MECKLENBURG COUNTY  
Park and Recreation Department

MEMORANDUM

**DATE:** May 25, 2023

**RE:** Rezoning Petition #2023-030  
PID# 05113202

# RZ-1.0

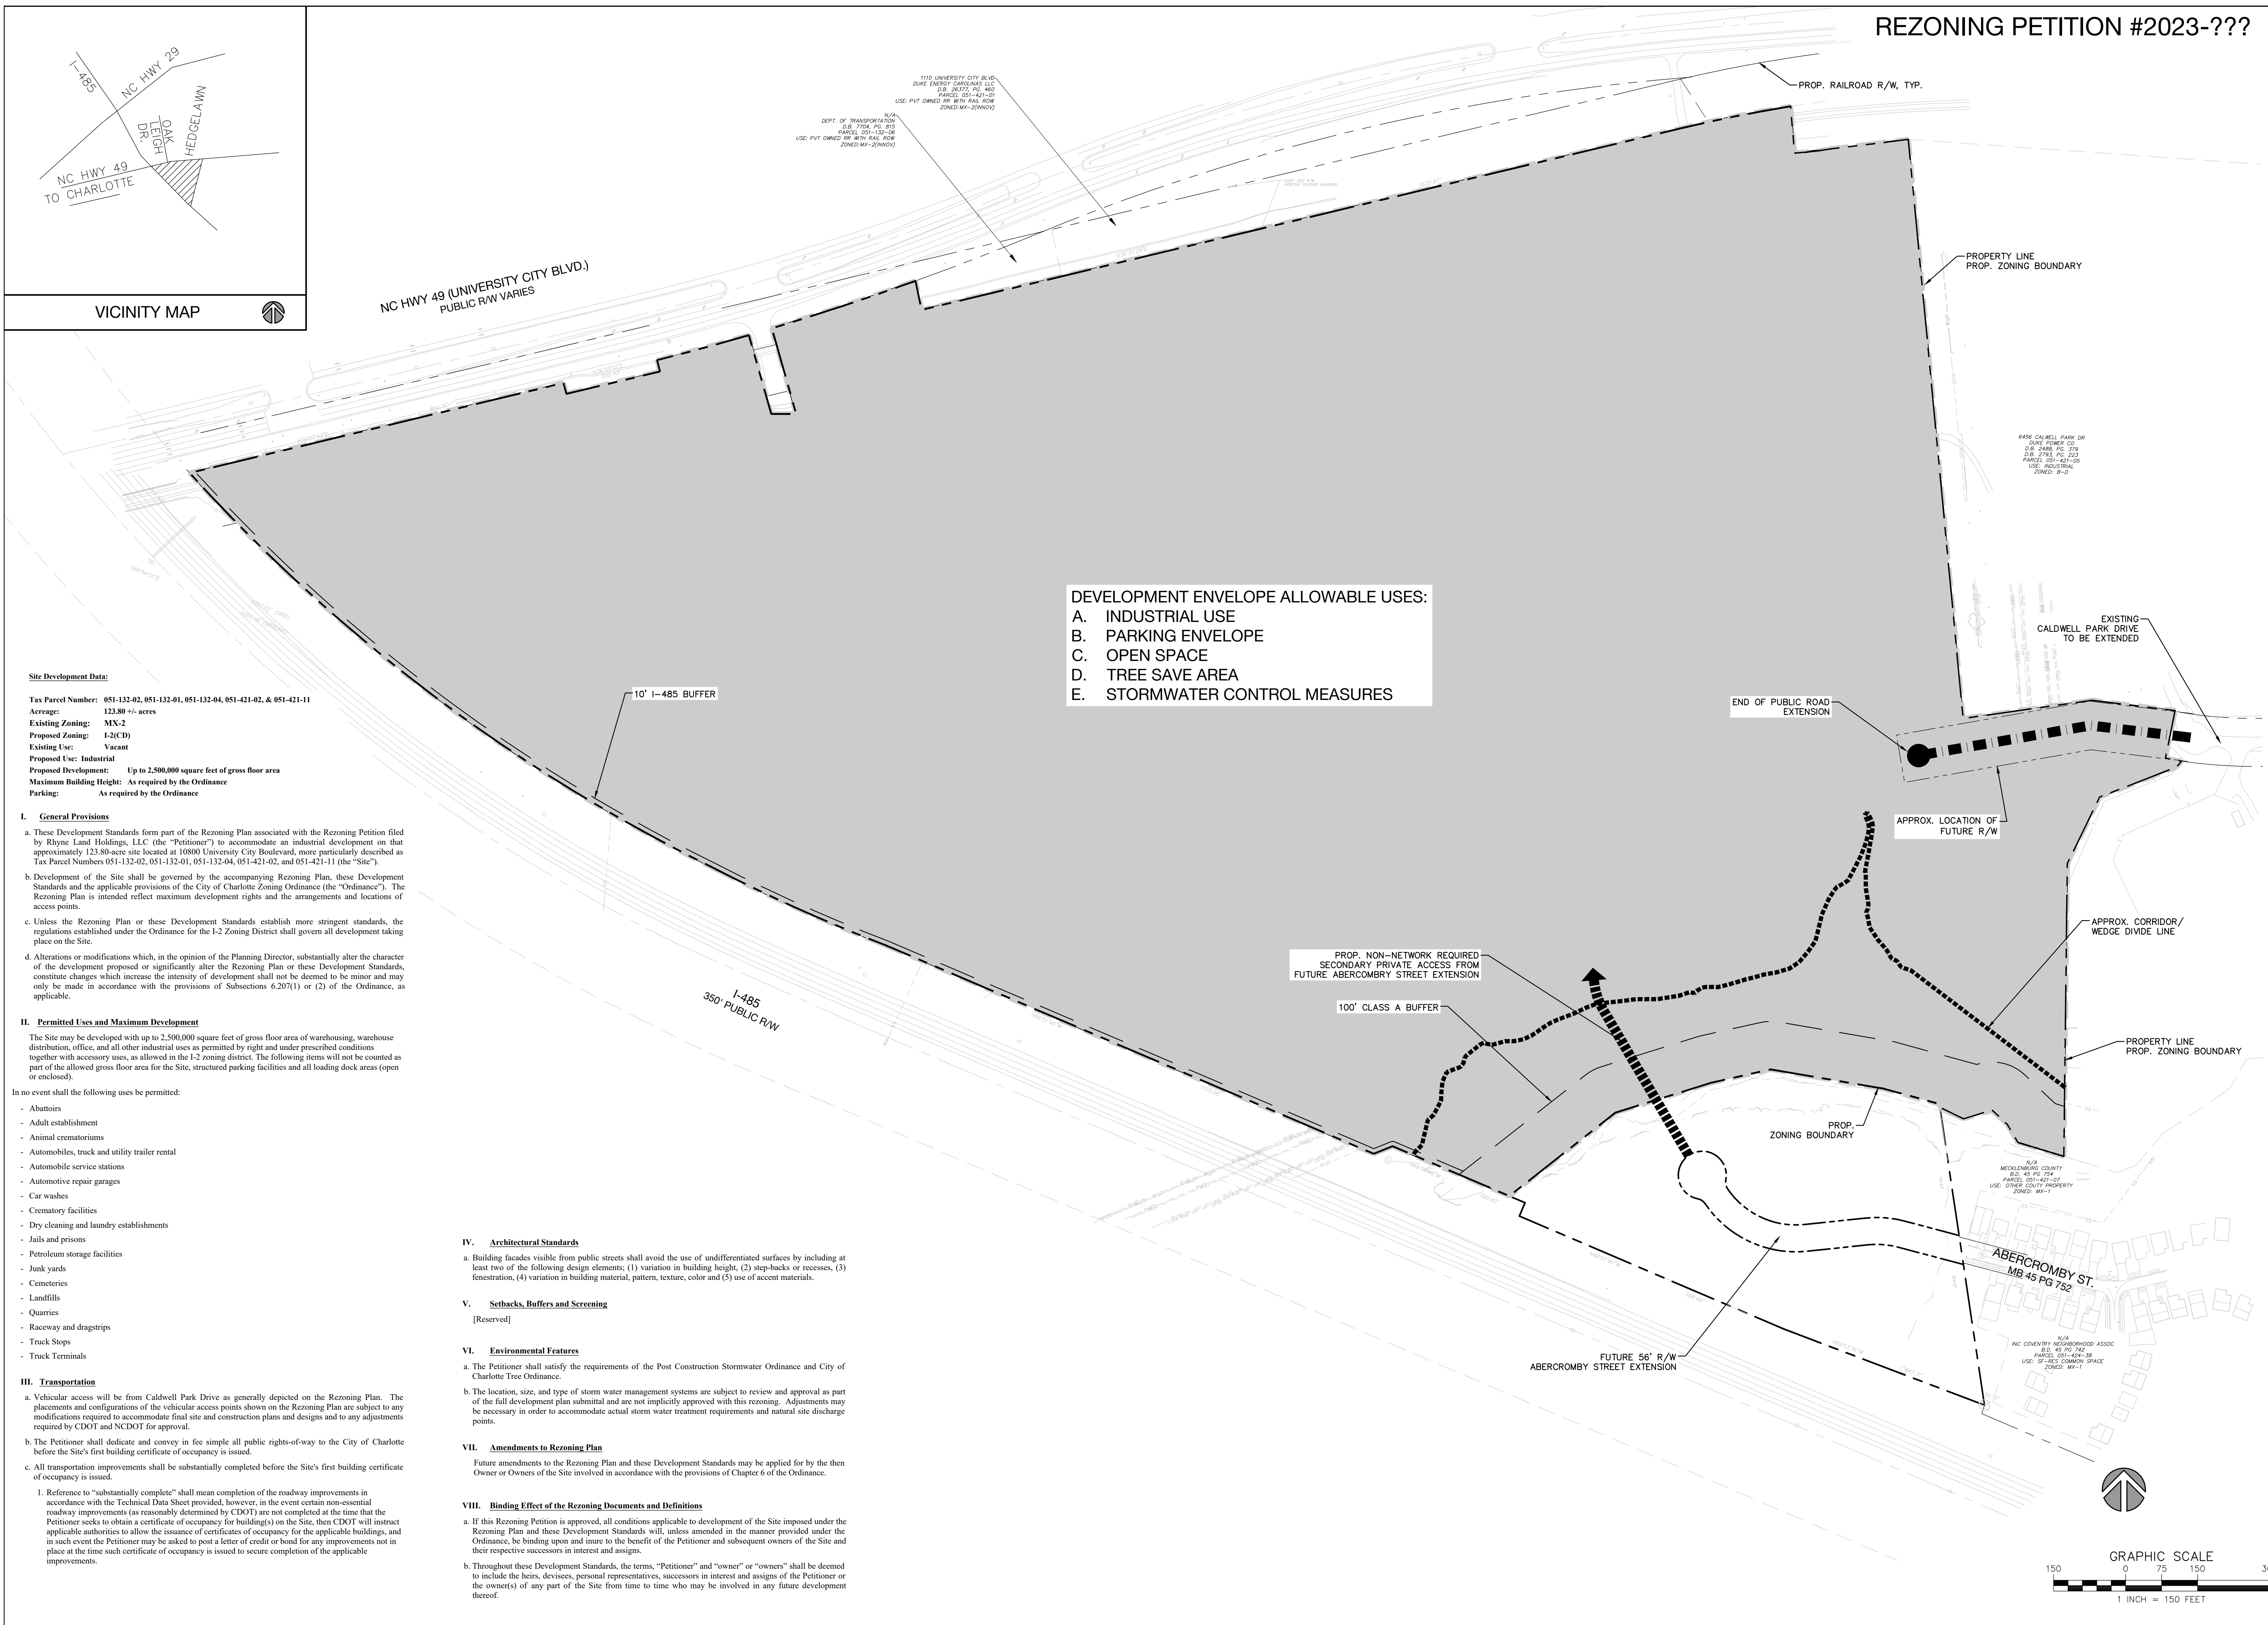
MCPR requests that the petitioner dedicate and convey to Mecklenburg County both the 100' SWIM buffer of Back Creek and a minimum of **6.0 acres** for a local park, preferably on the south side of Back Creek with access to Abercromby Street. Greenway dedication areas may overlap required tree save. The requested park land shall be adjacent to a public right-of-way for access and is conducive for the development of the typical amenities found in a neighborhood park and cannot include tree save parcels or stormwater BMP's.
